From: Tom Errico <thomas.errico@tylin.com>
To: Jean Fraser <JF@portlandmaine.gov>
CC: David Margolis-Pineo <DMP@portlandmaine.gov>, Katherine Earley <KAS@portlandmaine.gov>, Jeff Tarling <JST@portlandmaine.gov>, "JeremiahBartlett" <JBartlett@portlandmaine.gov>
Date: 1/23/2014 11:39 AM
Subject: 118 Congress Street - Final Traffic Comments

Jean - The following is a status update of my December 12, 2013 comments and represent my final comments.

3 PREFERRED SIDEWALK RAMP INTERSECTION (I-6E)  
NOT TO SCALE

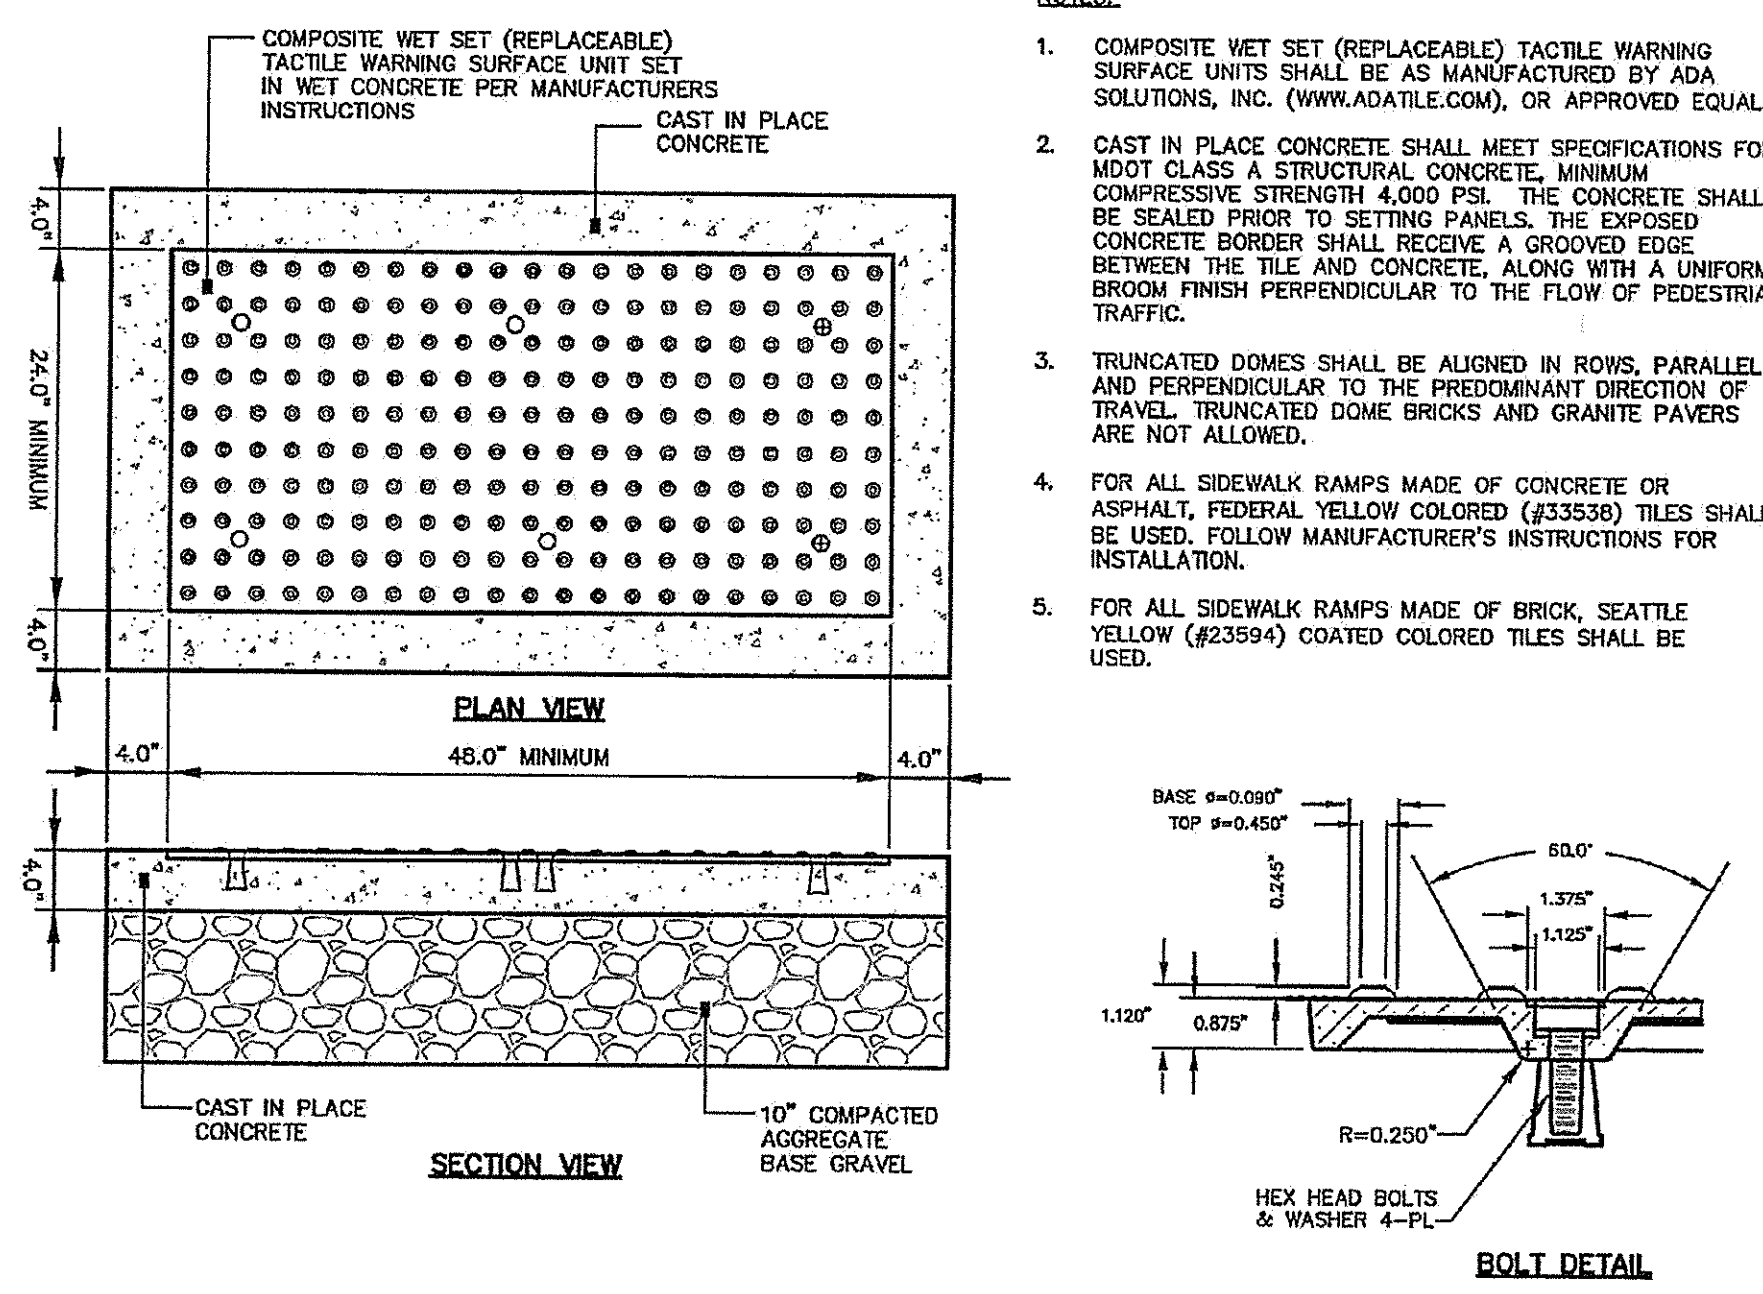
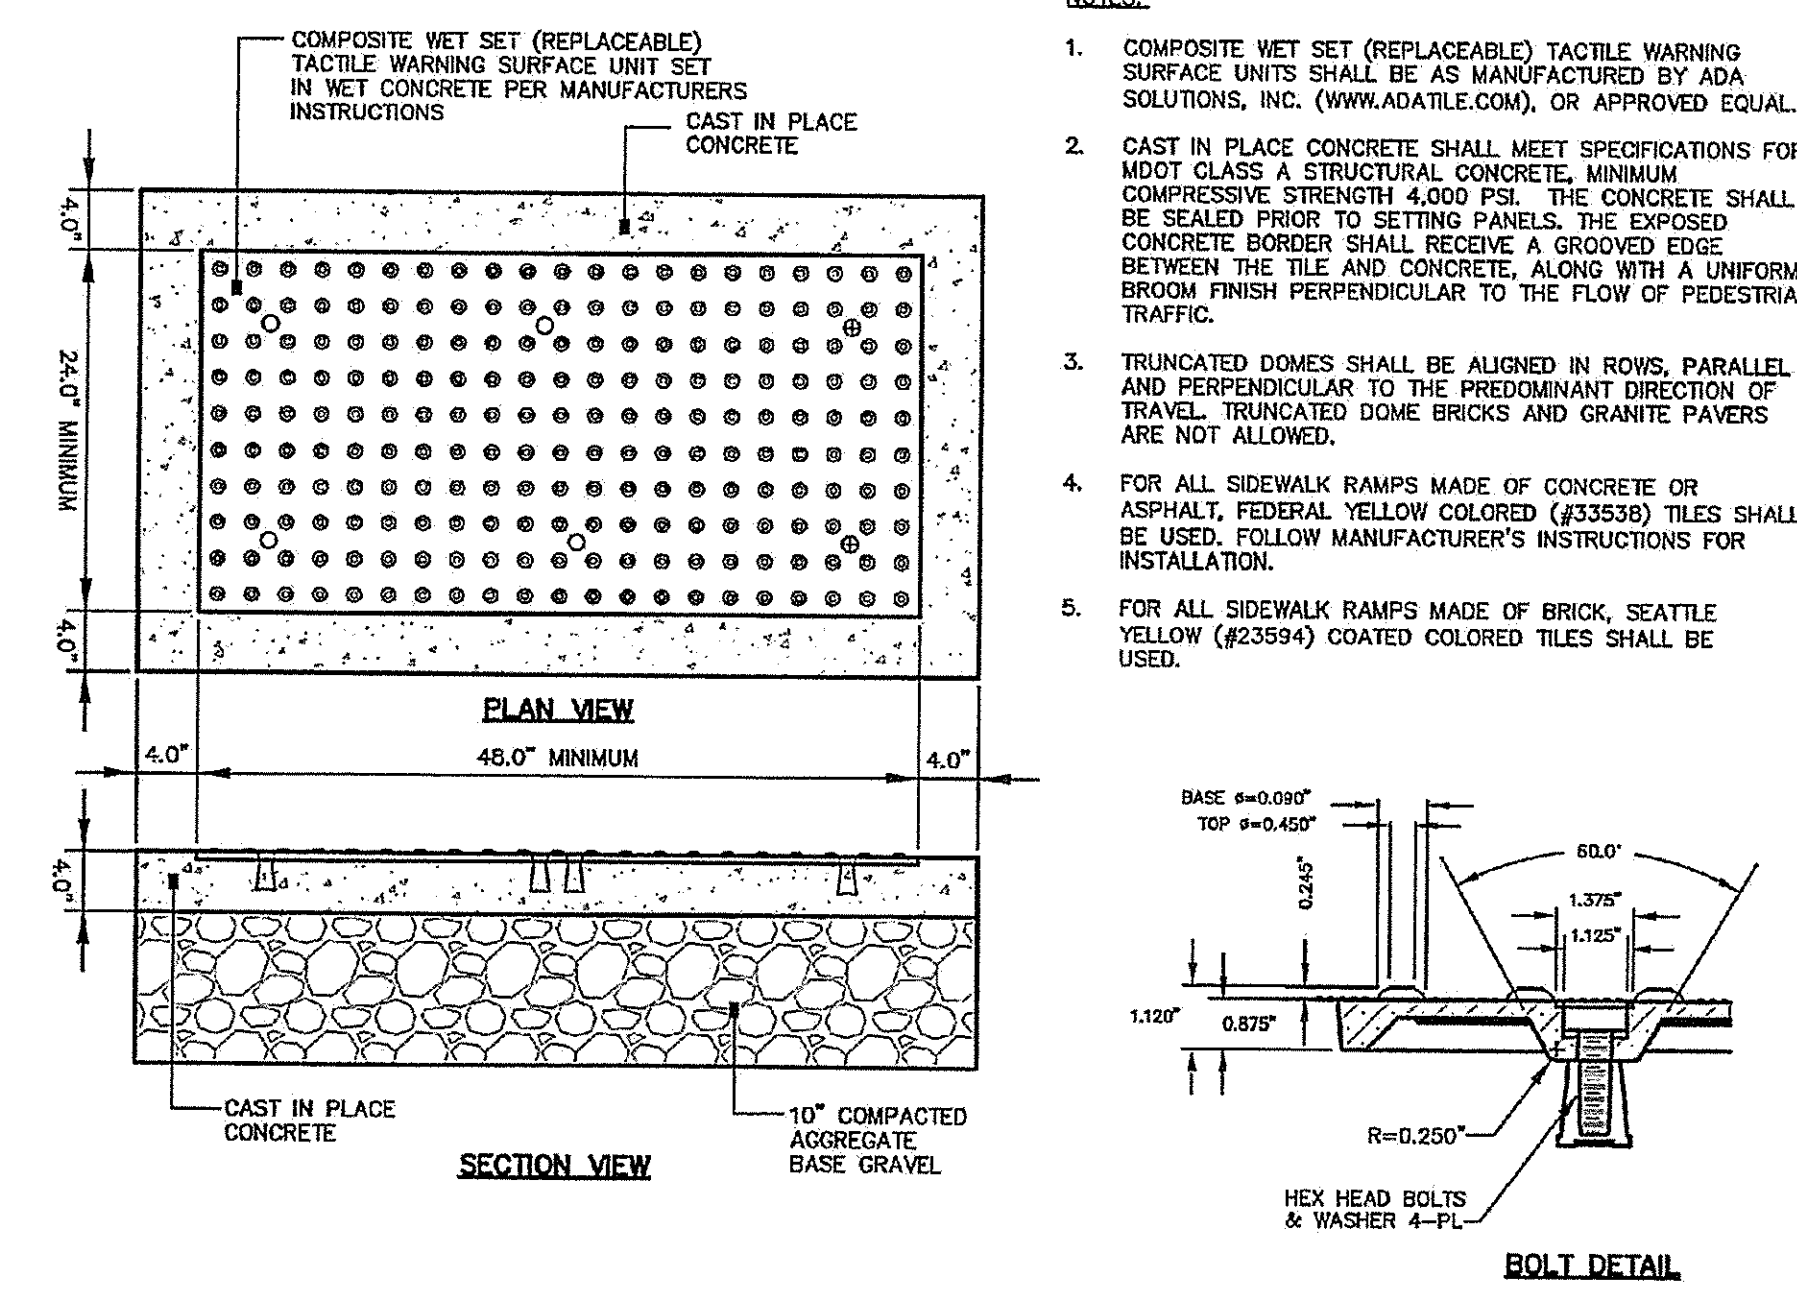
- * Historically a crosswalk has been provided on Congress Street at the easterly side of the St. Lawrence Street intersection. The City's Crosswalk Committee shall review the subject location and identify recommendations for installing a crosswalk. If deemed appropriate by the Crosswalk Committee the applicant will be responsible for installing the crosswalk and all supporting features.

Status: A condition of approval should be included that notes if a crosswalk is required by the City's Crosswalk Committee the applicant will be responsible for implementation of all features of the crosswalk including but not limited to pavement markings, signage, and ADA compliant ramps.

1 | PARKING LEVEL PROJECT FOOTPRINT: 8,986 GSF
1/8" = 1'-0"

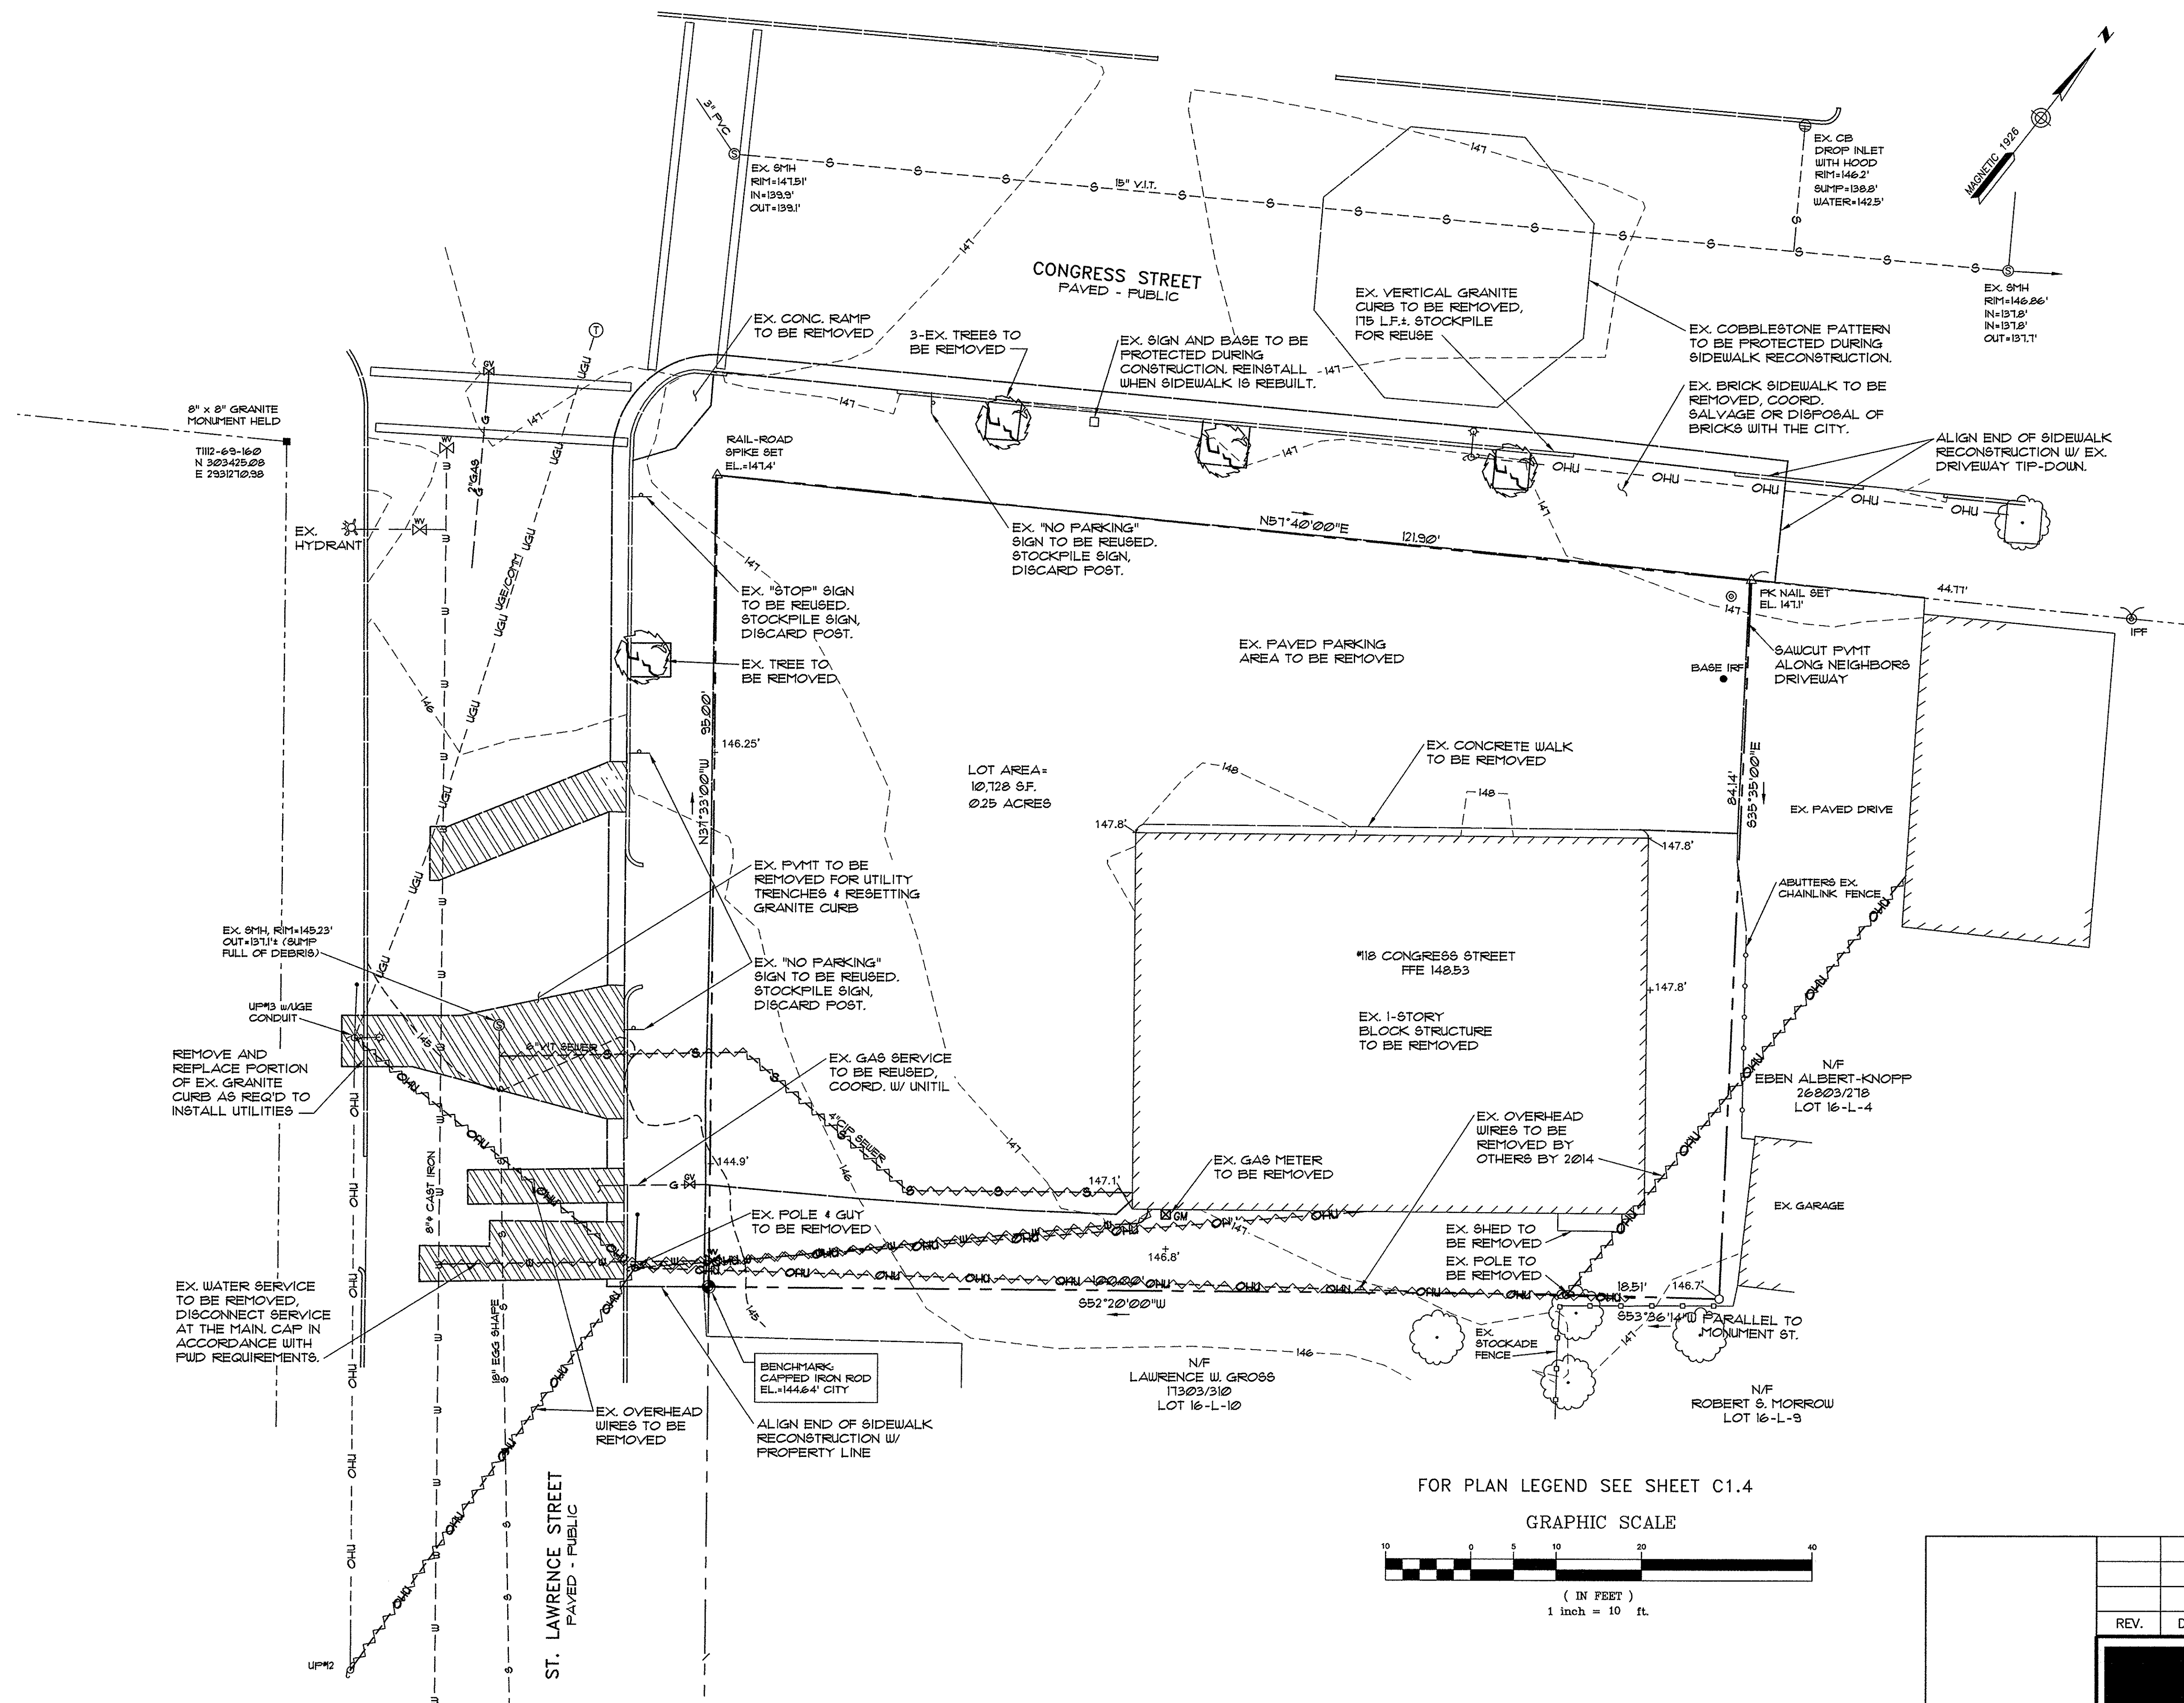
- * Some of the parking spaces on site do not meet City standards (reduced size - but larger than compact size spaces) and a waiver will be required. A formal waiver and supporting information shall be provided by the applicant.

Status: In addition to the request for a parking stall dimension waiver, the applicant is also requesting a waiver for a reduction in parking aisle width from 24 feet to 23 feet. I support waivers from these City standards.
